Response to Planning Application

From: Arun District Council Greenspace

Application ref: BN/62/21/PL

Location: The Croft Surgery Barnham Road Eastergate PO20 3RP

PROPOSED SITE PLAN

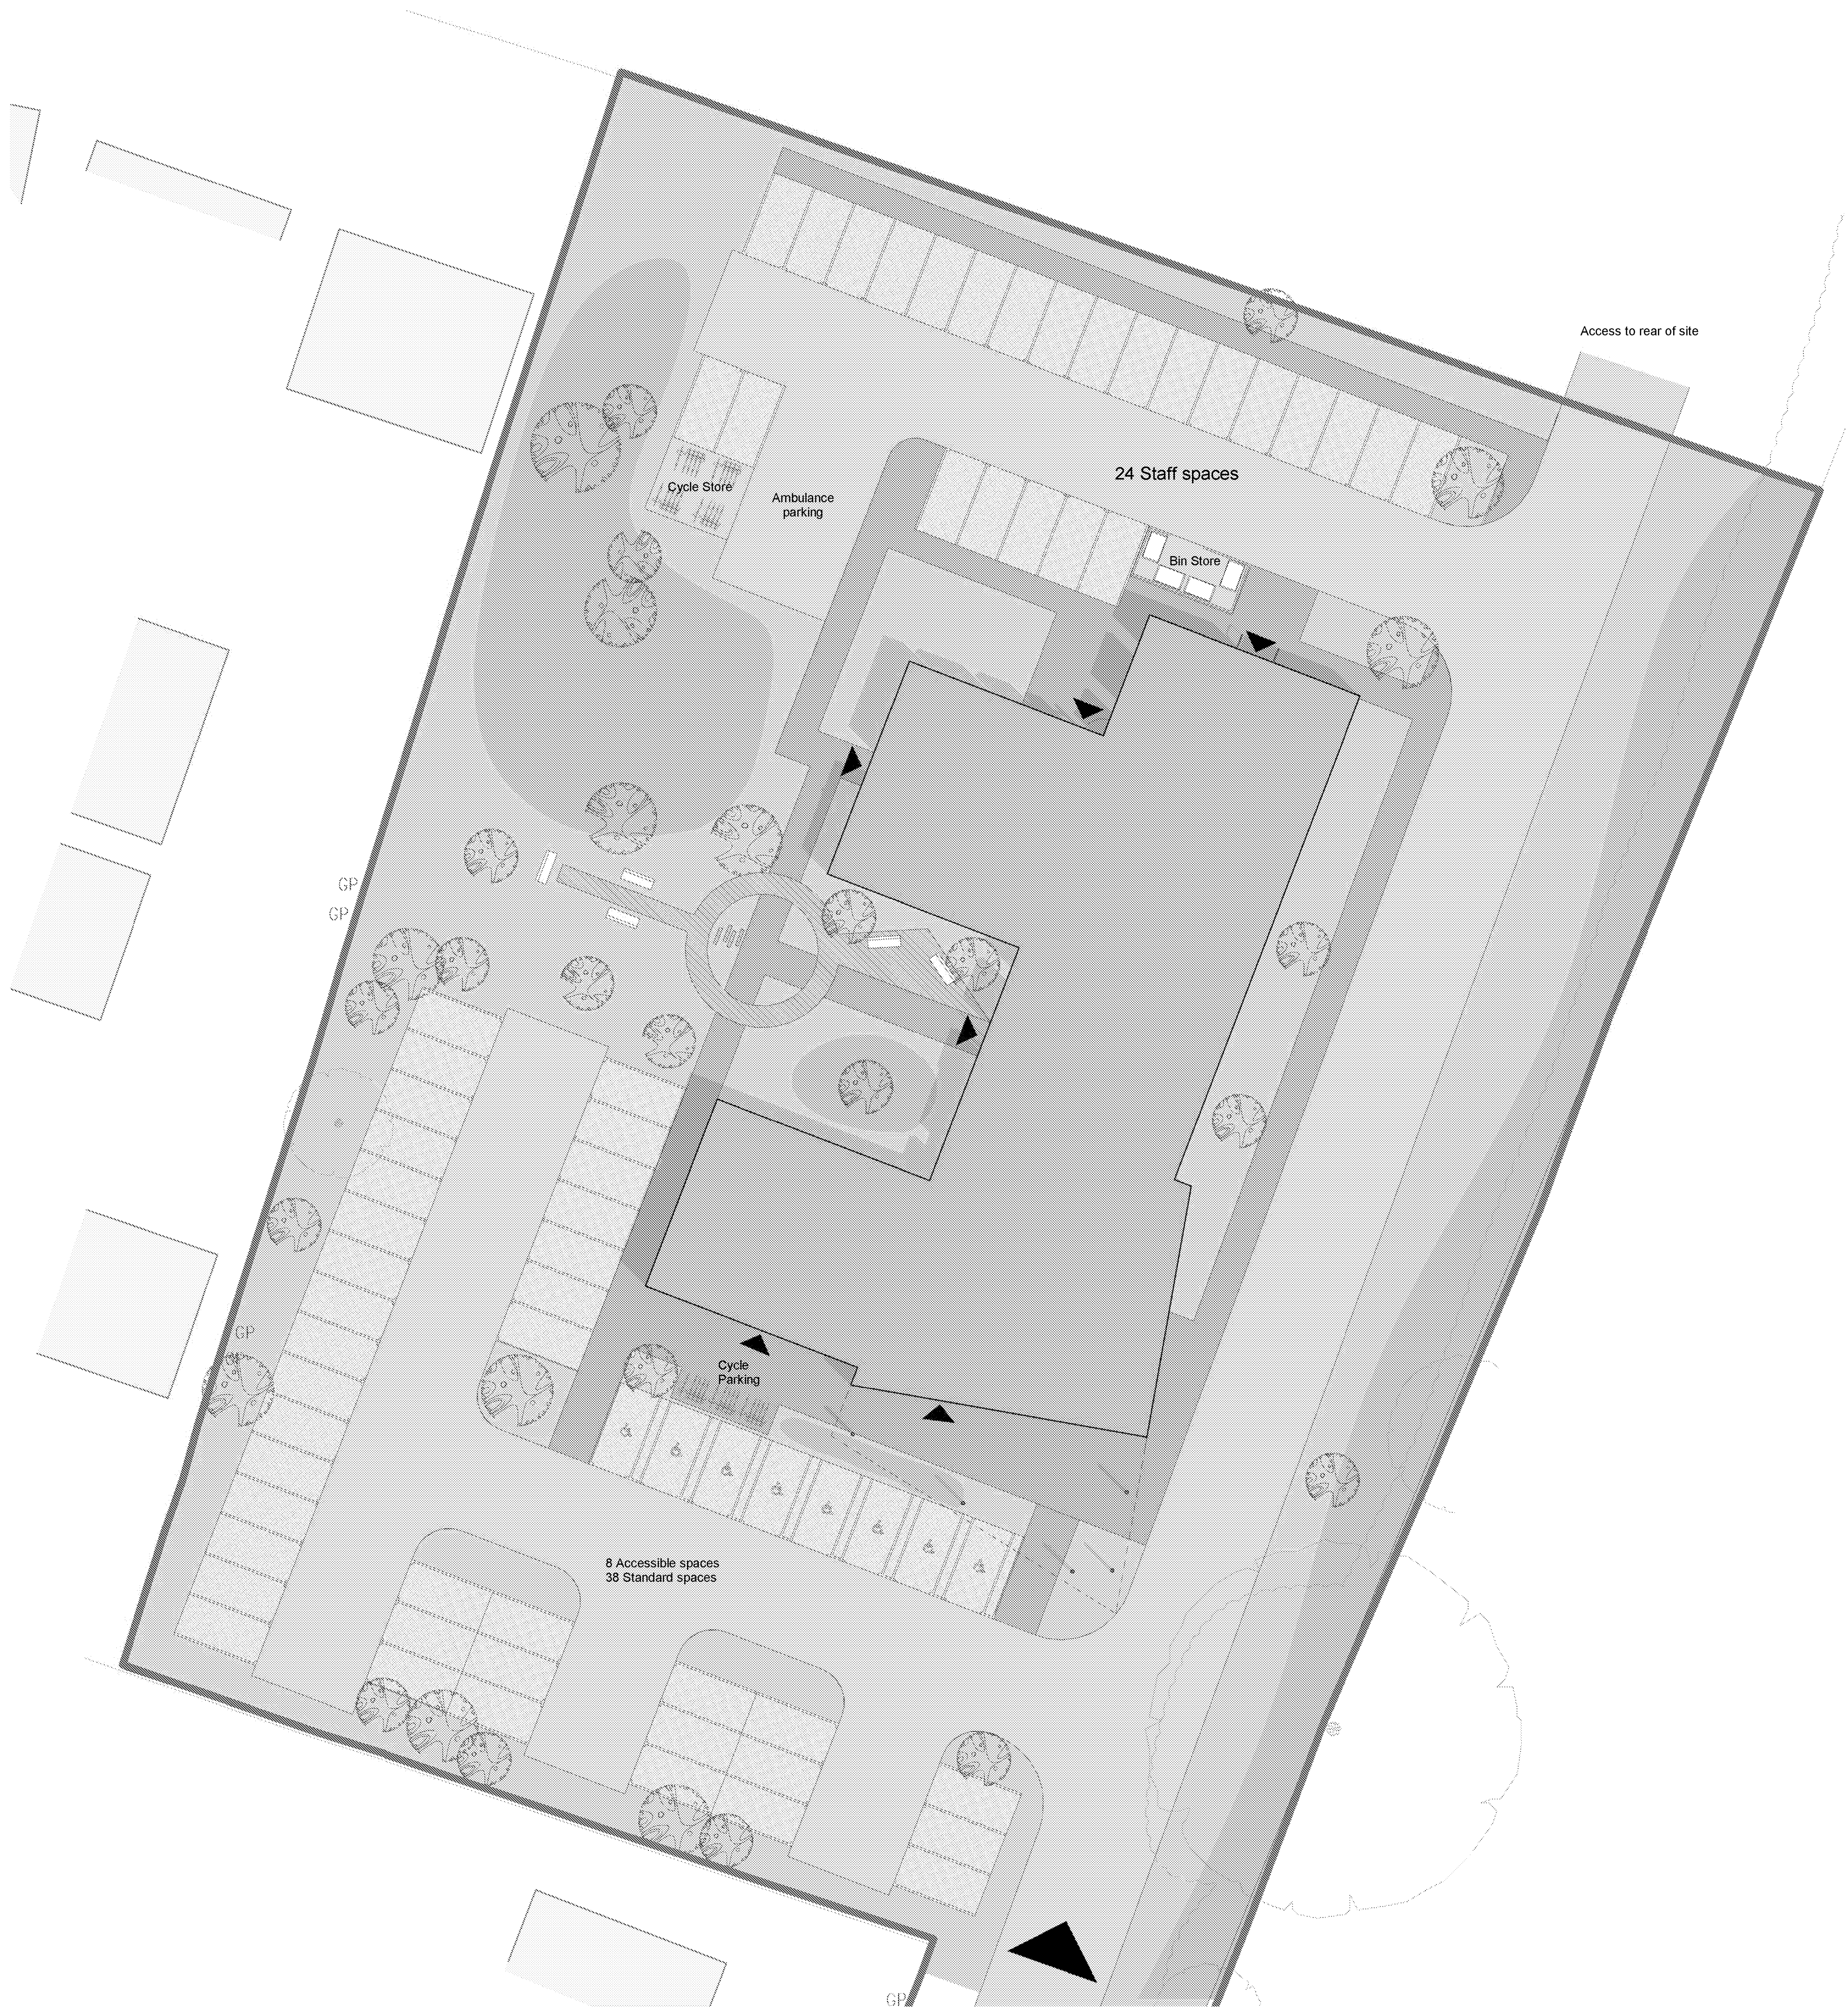
The proposals indicate a building, well set back from the road with a good area of associated carparking facility. Several existing mature trees and hedgerows are situated within this development parcel and will need consideration and protection. New planting will require detail to be supplied for approval and the proposed landscape scheme will need to maximise the biodiversity of the site with the inclusion of native species and the retention of a variety of habitats.

Existing trees and hedgerows along boundaries where established must be protected and retained and would require further planting to infill if found to be required. New tree and hedge planting would be required to infill sections where there are gaps and missing sections. This is particularly required to the southern and western boundaries of the site, where the proposals border neighbouring properties.

Pedestrian and cycle routes to this facility should be a considered design features and their meaningful connection to beyond the site detailed.

A full landscape scheme should be submitted for approval, detailing species choice, position, densities and size at time of planting. This should be plotted in plan and list form and in relation to the trees and vegetation to be retained so that a clear picture of the proposals can be seen. These details are required to assure the adjacent properties privacy is maintained and the surrounding landscape is uncompromised. The landscape masterplan overall 957-MP-01-Rev C shows this in some detail but in indicative form only, further plan detail with annotation would be required. The privacy and views of the adjacent existing properties have the potential to be compromised by the proposals and full consideration of mitigation planting to offset the impact should be considered within the landscape design.

TREE PRESERVATION ORDER:
Arun District Council website has confirmed that T10 is protected by a
Tree Preservation Order, reference TPO/EG/11/17.

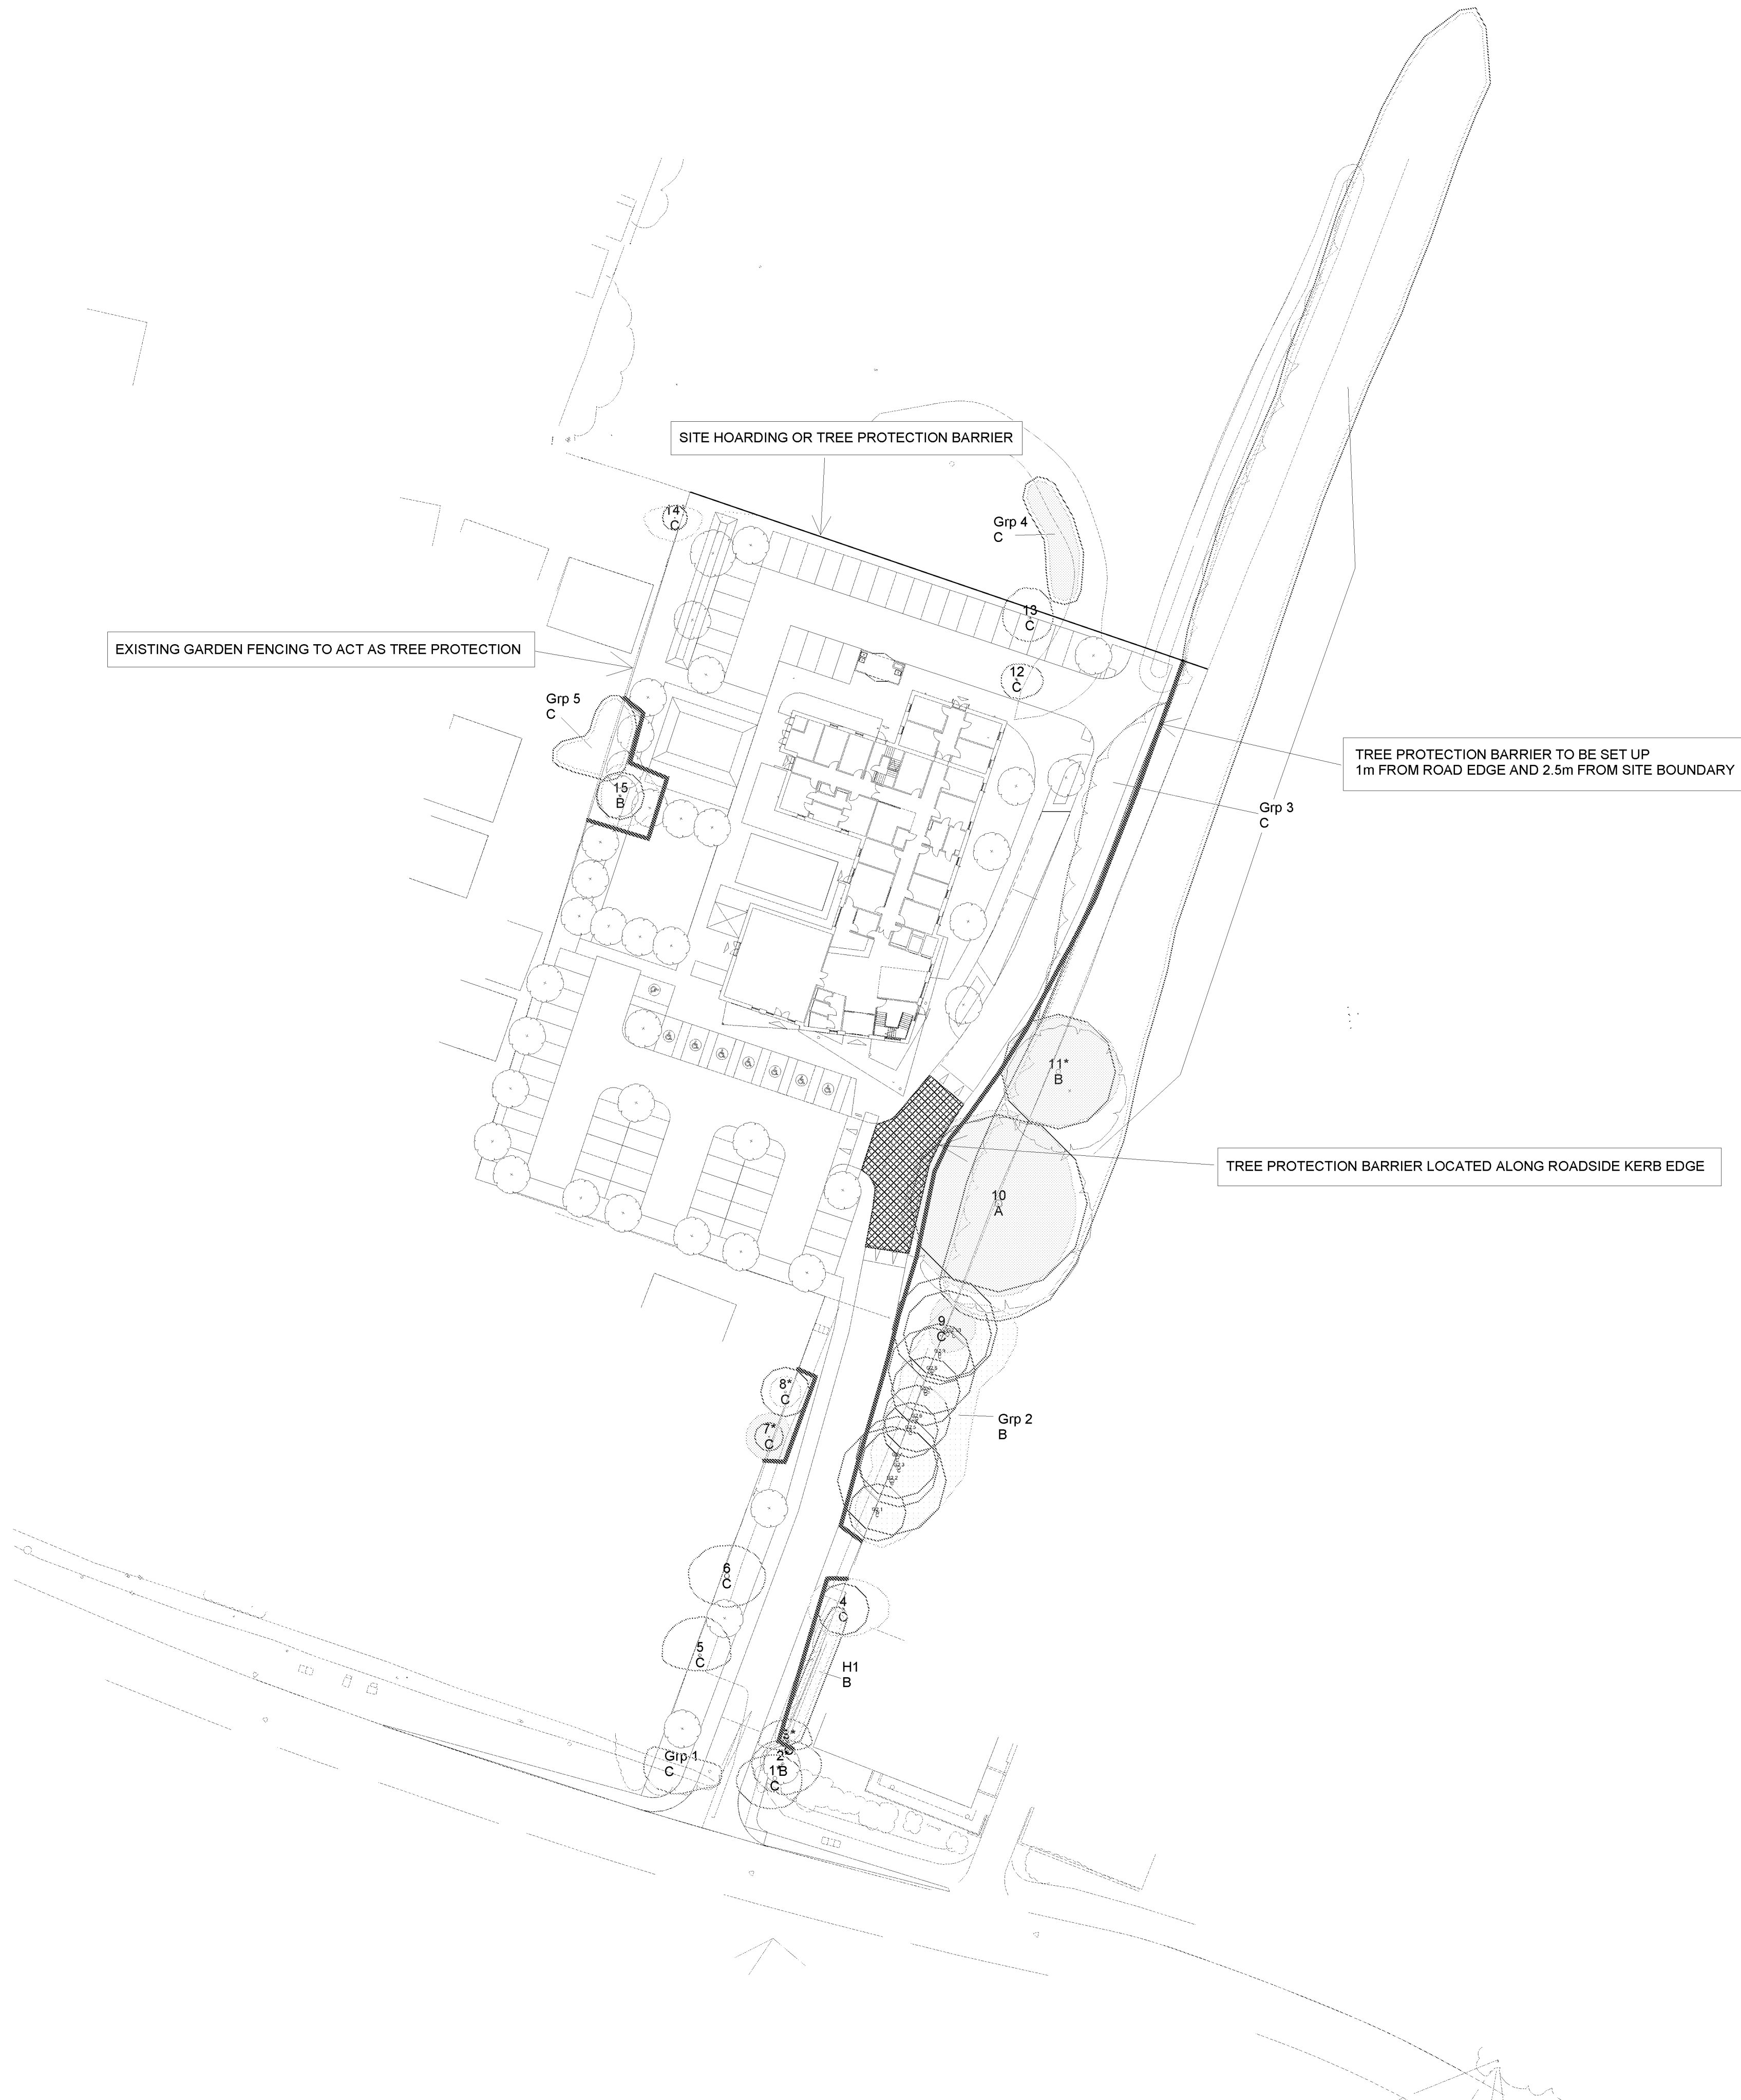
Consideration of existing trees and hedges within the site would be required and any removals agreed with Arun District Councils Tree Officer.

Arun District Councils Tree officer would need to be consulted regarding any proposed tree works. We note the tree cover to the periphery of the site which possess several existing significant trees including those located to the proposed access road and to the east of the site, which would require tree protection zones to be in place before any construction begins. This would be required for any retained trees including trees those whose root protection areas fall within the construction zone from neighbouring land; beyond the site boundary. This should be in accordance with BS 5837:2012 'Trees in relation to construction'
